REQUEST

Current Zoning: MUDD-O SPA (mixed-use development district, optional, site plan amendment)
Proposed Zoning: MUDD-O SPA (mixed-use development district, optional, site plan amendment)

SUMMARY OF PETITION

The petition proposes to combine four apartment buildings into two buildings without an increase the number of dwelling units. The site is currently developed with two new structure-parked apartment buildings and 17 garden-style apartment buildings dating from the 1960s.

RZ-100

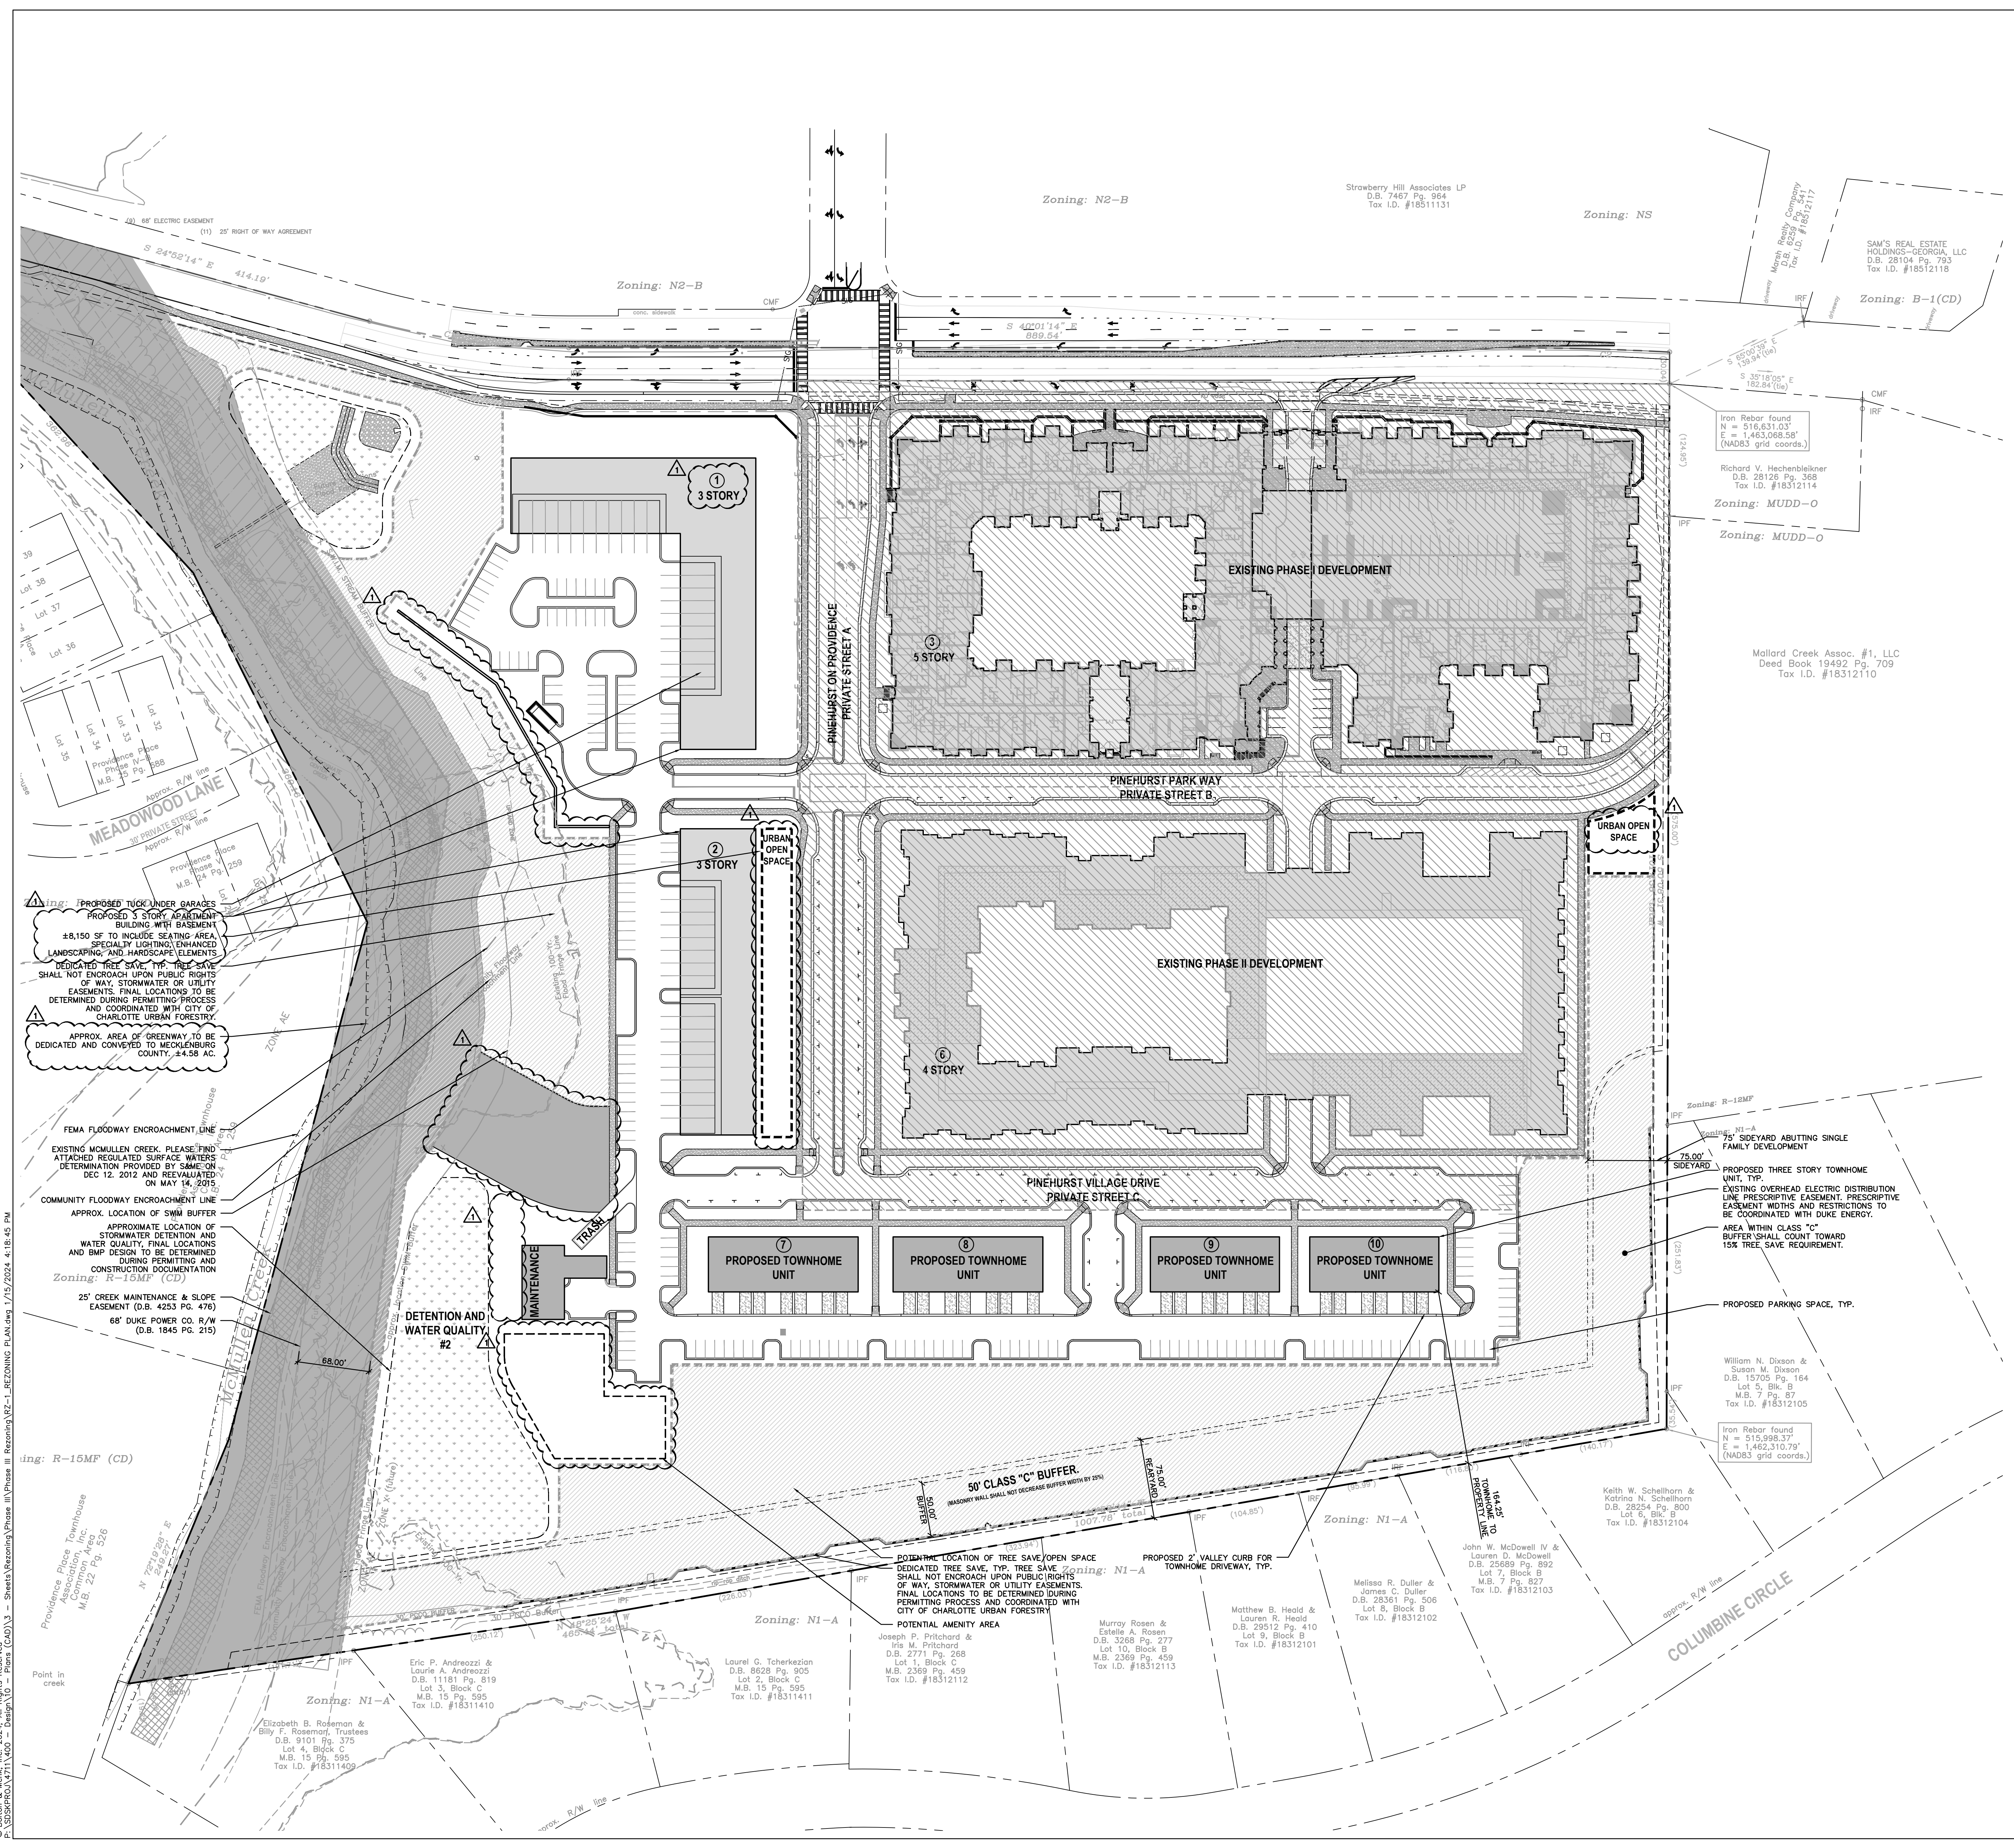
1. Mecklenburg County Park and Rec: The proposed greenway access easement must connect to the public street ROW to provide Mecklenburg County access to the greenway dedication area. This easement shall overlap with the private street between the public street ROW and the greenway area.

2. Mecklenburg County Park and Rec: To clarify the previous note, Mecklenburg County requests a vehicular access easement from Providence Road to the 100' Greenway Easement along the private development streets.

4. ~~Stormwater Services Land Development: Update label to say "100' SWIM and Post Construction Buffer." Buffer should be shown as extending 100' from top of bank. **Addressed**~~
-
